East Pye Solar
Statement of Common Ground: South Norfolk
District Council

Revision 1
October 2026

Planning Inspectorate Reference: EN0110014
Document Reference: EN0110014/EXAM 9.5
Rule 8(1)(e) Infrastructure Planning (Examination Procedure) Rules 2010

- VL : View Location
- CRC : Cable Route Corridor
- BESS: Battery Energy Storage Systems

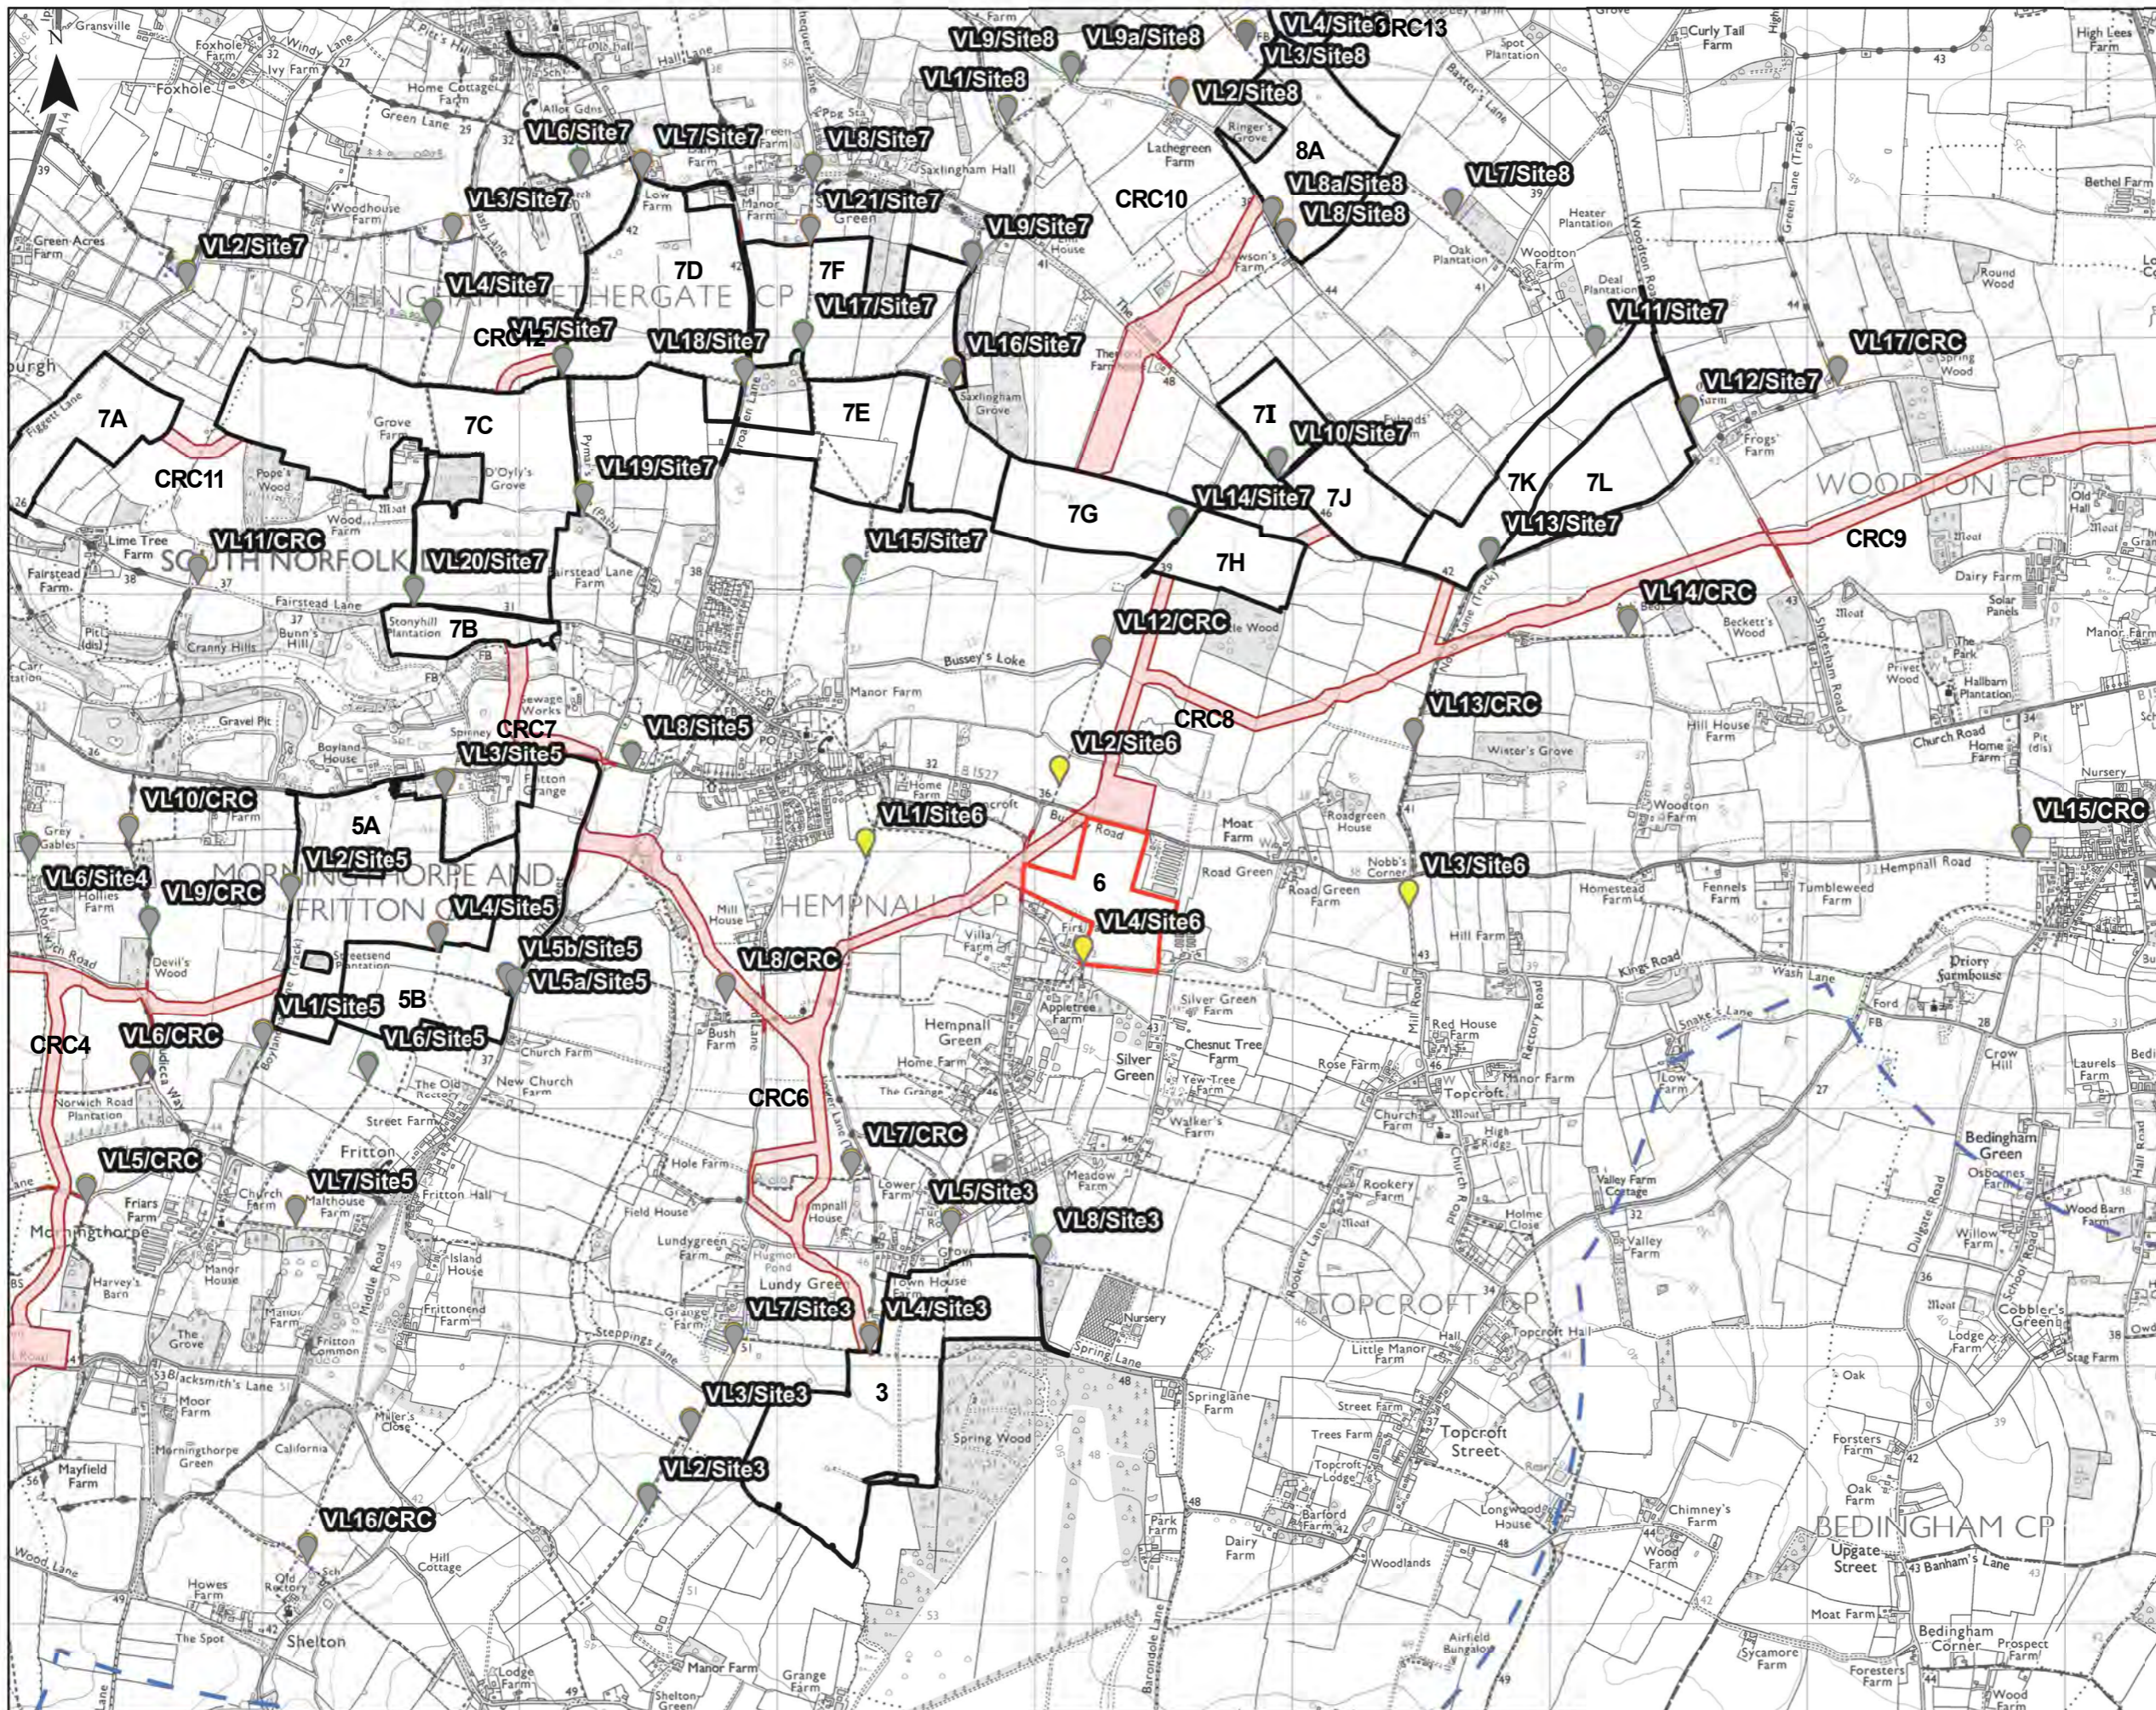
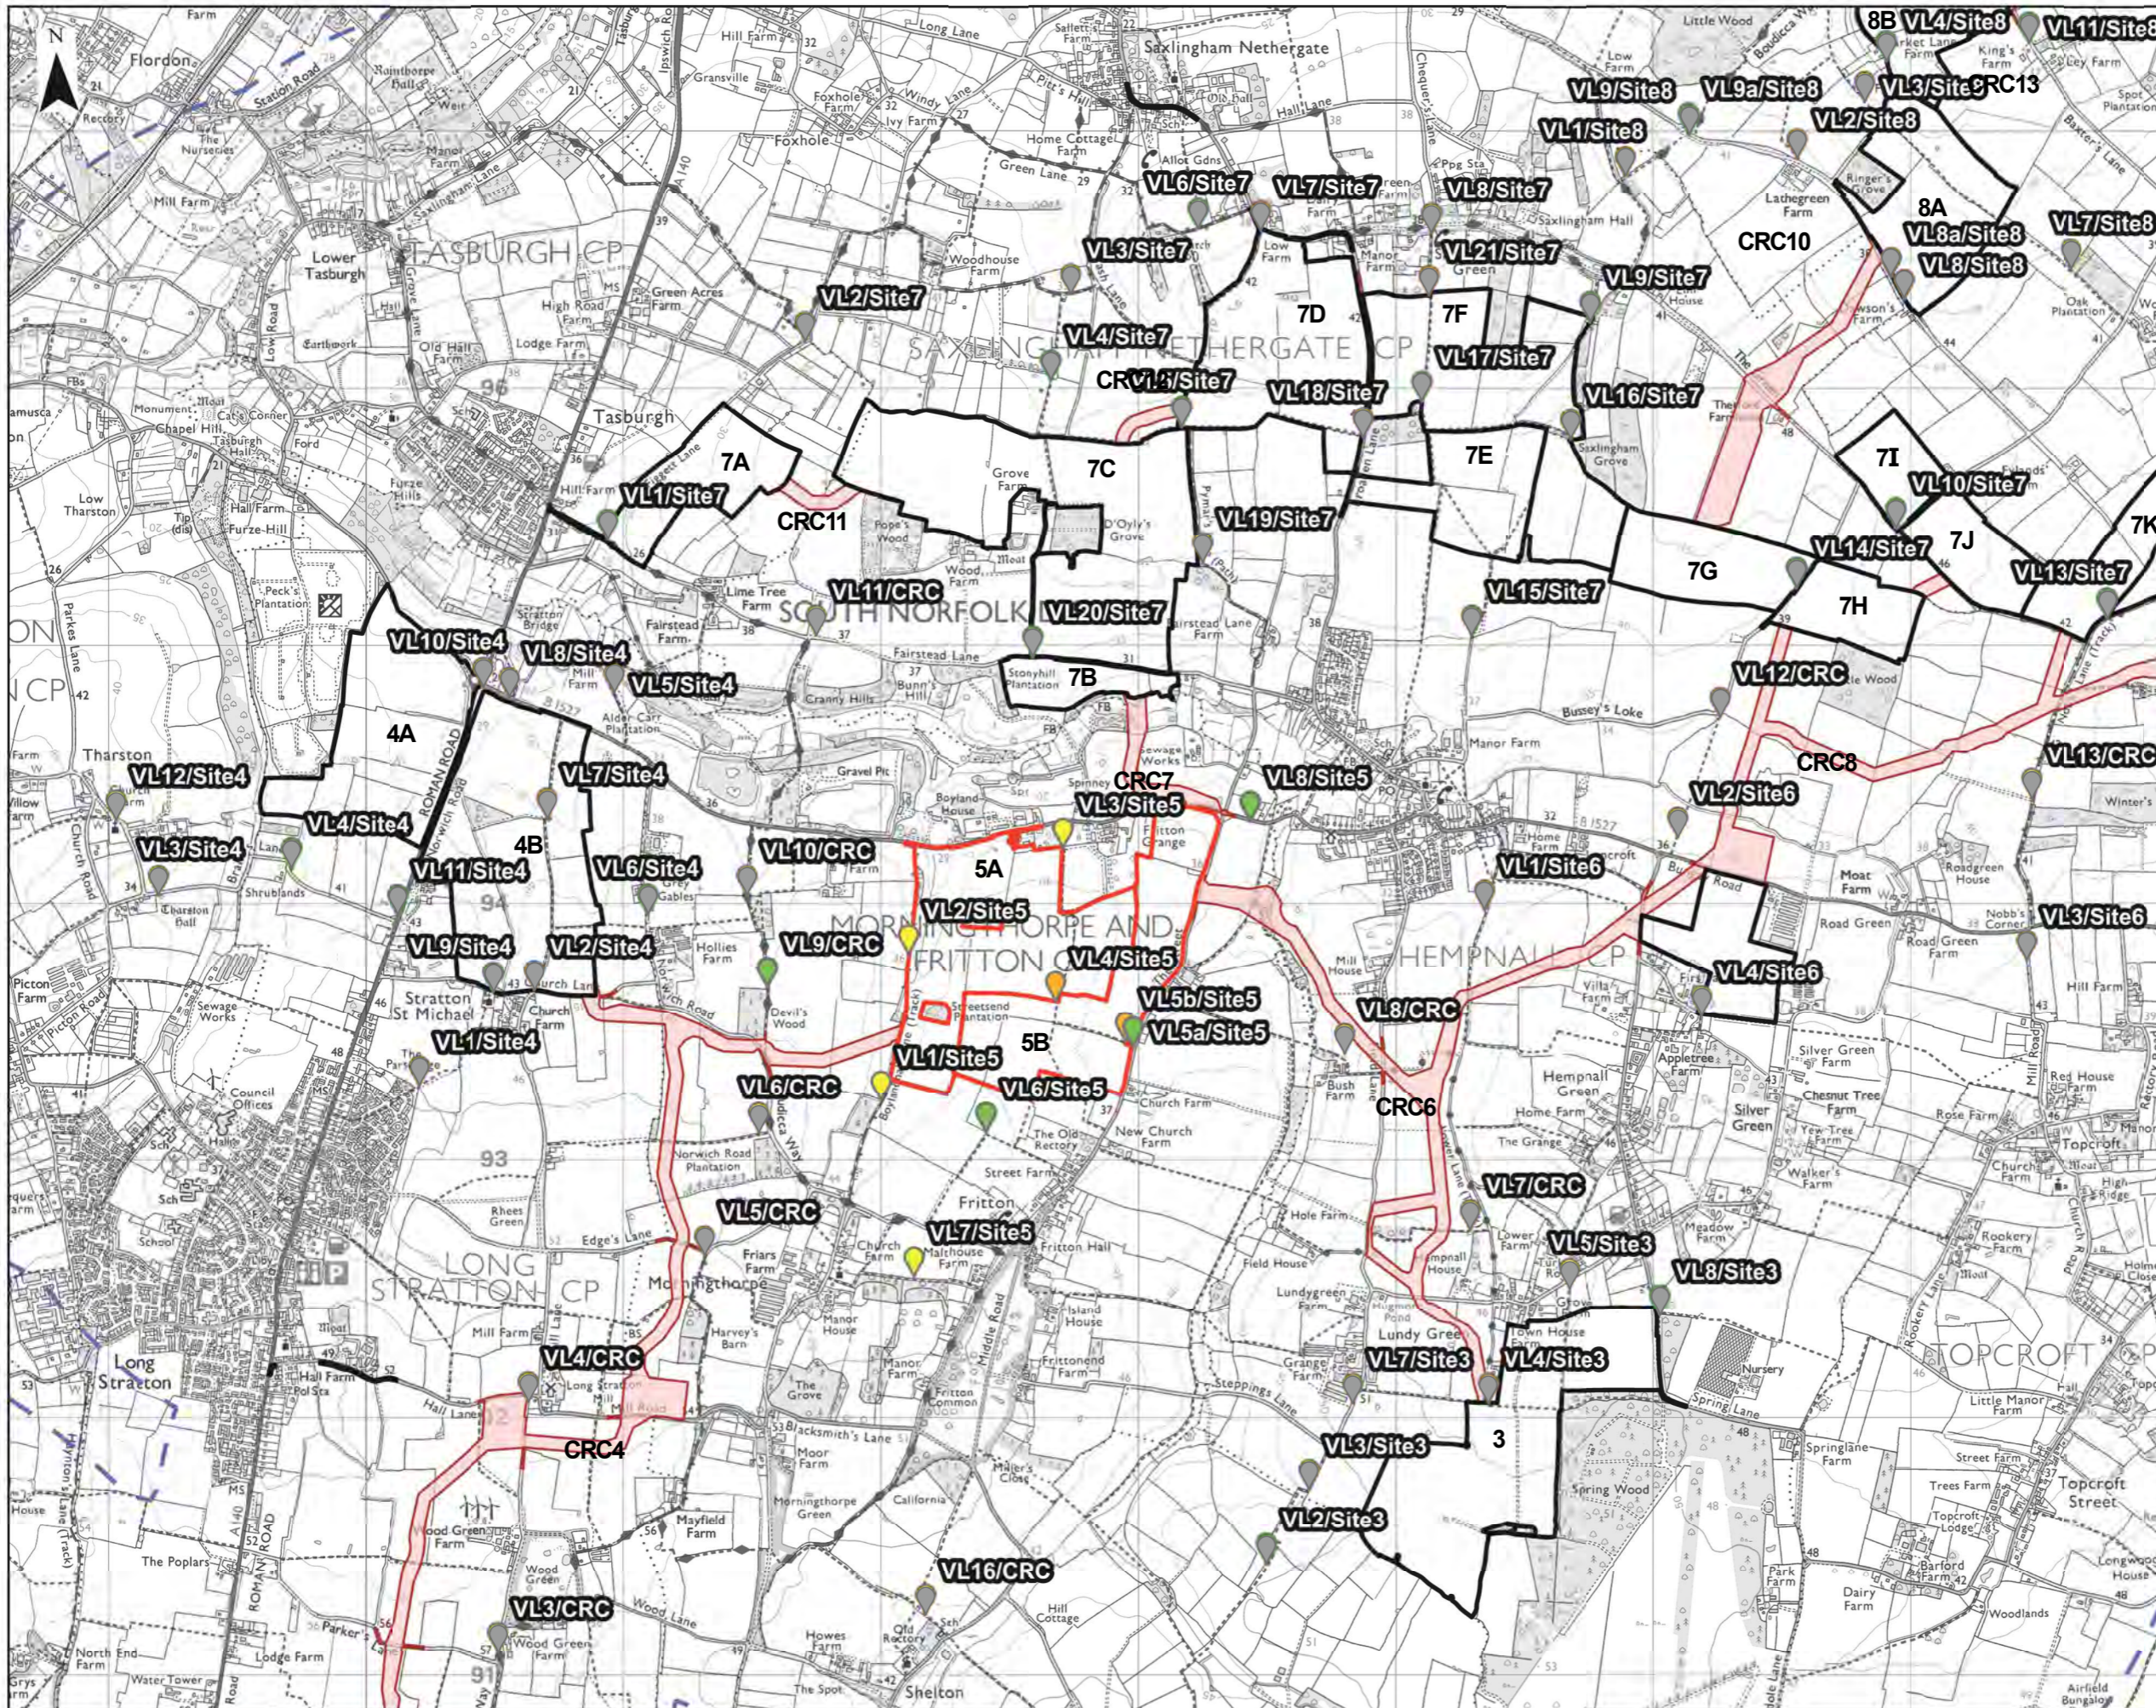
SNDC LV - 8	Scope View Location selection	ES Volume 1, Chapter 7 - Landscape and Visual [APP-043] ES Volume 2, Figure 7.7 - View Locations and Visualisations [APP-082]	The Applicant consulted with SNDC to agree view locations, and SNDC is content with the submitted materials.	The Applicant has undertaken consultation with the Landscape Officer in respect of the selection of assessment view locations. In response to comments received, a number of additional view locations have been incorporated into the assessment, including: VL8/Sub, VL8/LP2, VL7/LP3, VL8/LP3, VL9-VL12/LP4, VL7/LP5, VL9-VL11/LP8, VL7/LP9, VL10/LP10, VL16 and VL17/CR.	Agreed

SNDC LV – 10	Scope Visualisation for Landscape and Visual Assessment	ES Volume 1, Chapter 7 - Landscape and Visual [APP-043] ES Volume 3, Appendix 7.1 - Landscape and Visual Methodology [APP-118] ES Volume 2, Figure 7.7 - View Locations and Visualisations [APP-082]	SNDC agree that the submitted visual technical visualisations cover a reasonable number of viewpoints and locations however they should have been prepared as Type 4, not Type 3, to guarantee an appropriate level of accuracy for such complex and sensitive development.	The Applicant has consulted with the Landscape Officer in respect of the location and type of visualisations to be produced, but no response was received. The location and type of visualisations are illustrated in ES Volume 2, Figure 7.7 - View Locations and Visualisations [AS-009]. The methodology for visualisation production is set out in ES Volume 3, Appendix 7.1 - Landscape and Visual Methodology [APP-118]. The visualisations have been prepared in accordance with industry-standard guidance, specifically the Landscape Institute [2019] Visual Representation of Development Proposals Technical Guidance Note 06/19 [TGN 06/19]. The types of visualisation produced include: • Photowires [LI TGN 06/19 Type 3]; • Photomontages / Photowires for Winter Year 1 [LI TGN 06/19 Type 3] with no landscape measures shown; and • Photomontages Summer Year 15 [LI TGN 06/19 Type 3] with established landscape measures shown. The parties will continue discussions regarding the requirement and potential locations of Type 4 visualisations.	Under discussion

Reference	Matter Topic	Document Reference of Matters	Consultee Position	Applicant's Position	Status
				The view locations presented within ES Volume 1, Chapter 7 - Landscape and Visual [APP-043] and ES Volume 2, Figure 7.7 - View Locations and Visualisations [APP-082] are therefore considered to provide an appropriate and robust basis for establishing baseline landscape and visual conditions.	
SNDC LV-9	Scope View Location Selection	ES Volume 1, Chapter 7 - Landscape and Visual [APP-043] ES Volume 2, Figure 7.7 - View Locations and Visualisations [APP-082]	Following a review of the submitted documents with the DCO, SNDC consider that additional viewpoints from the Via Beata, Boudicca Way, and from footpaths within the sites or on the site's boundaries would be beneficial to illustrate worst-case scenarios and the extent of change for sensitive visual receptors and the suggested locations are listed in SNDC's Local Impact Report.	This matter will remain under discussion until SNDC's Local Impact Report is received.	Under Discussion
